2850 S. Meridian Road, AL-24-6

Please accept the following comments from El Paso County Public Health (EPCPH) for the special use project referenced above:

2850 S. Meridian  
Colorado Springs, CO 80929

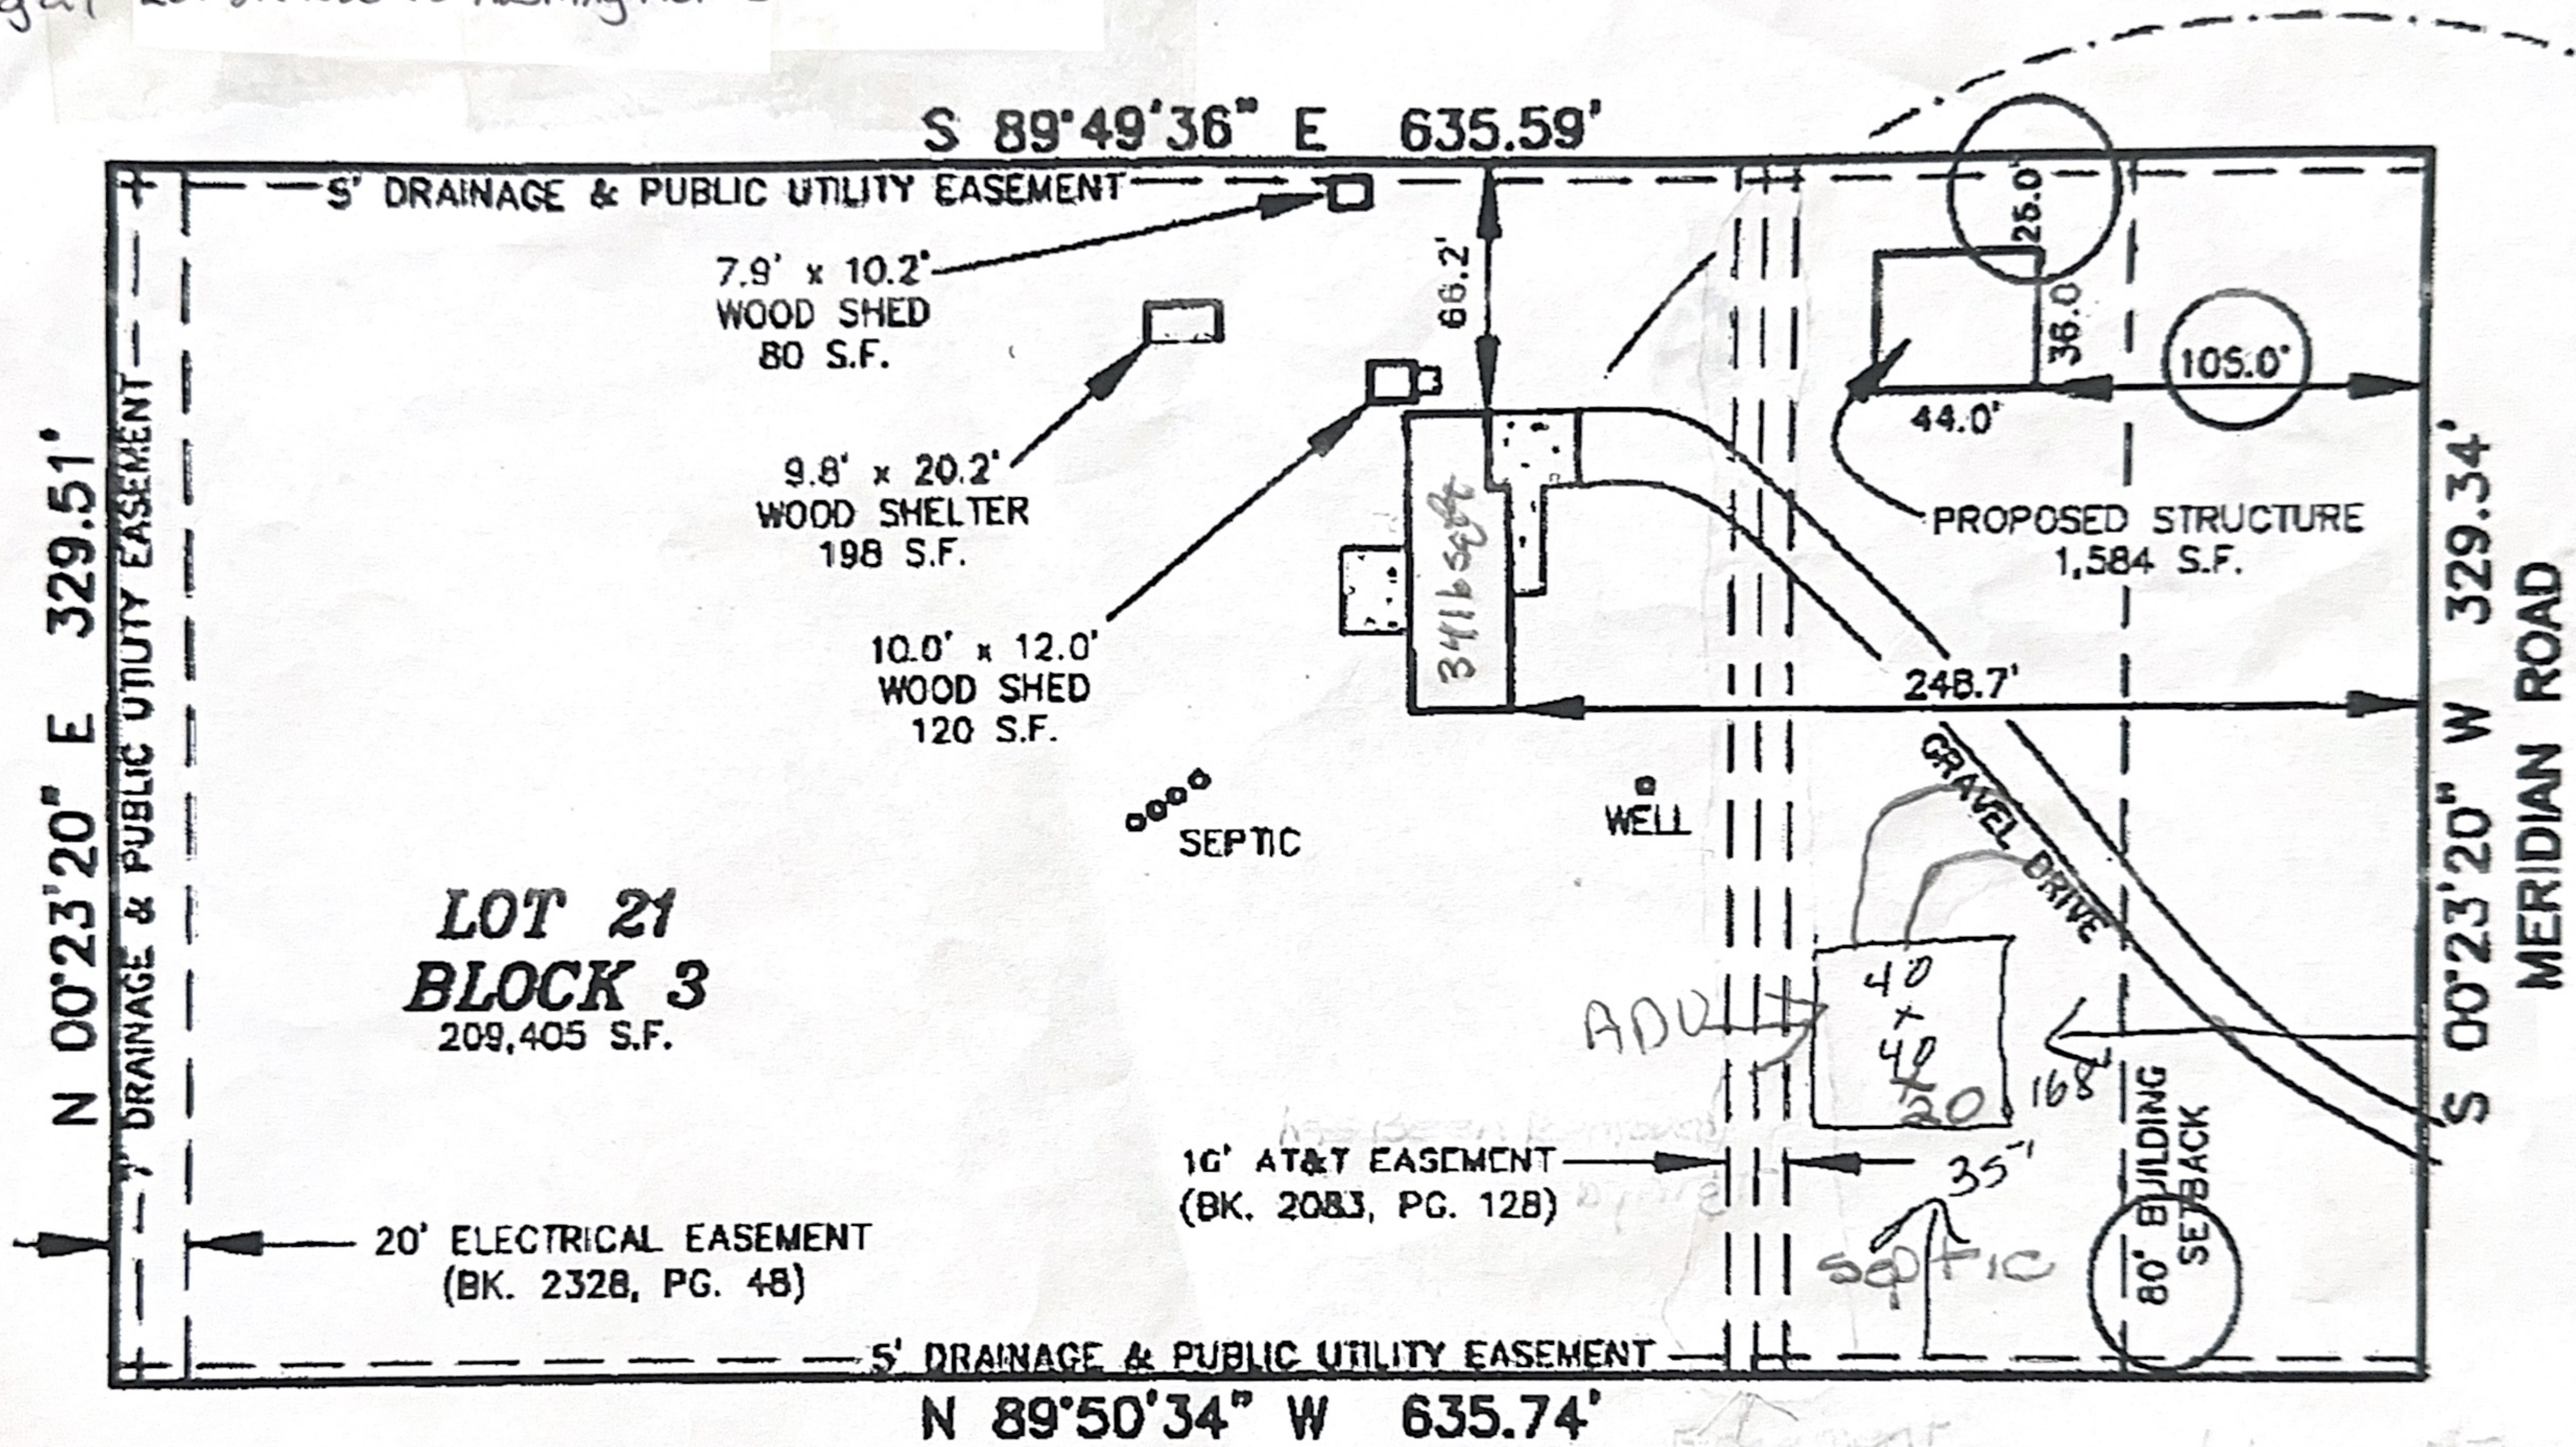
- Water service for the existing house is by an individual private well.
- Wastewater service for the existing house is an onsite wastewater treatment system (OWTS) permitted, installed, and approved in 2008 for a 4-bedroom house. No wastewater plans for the second dwelling were submitted for review. For the conversion of the detached garage into a second dwelling there are basically two options:

- The existing well is likely the water source of the proposed second dwelling. A new water line from the well serving the existing house is assumed to be the source of water for the proposed second dwelling. This new water line between the well and the second dwelling must meet the minimum setback from all building sewer lines, or the water line must be properly encased as required by the OWTS regulations.
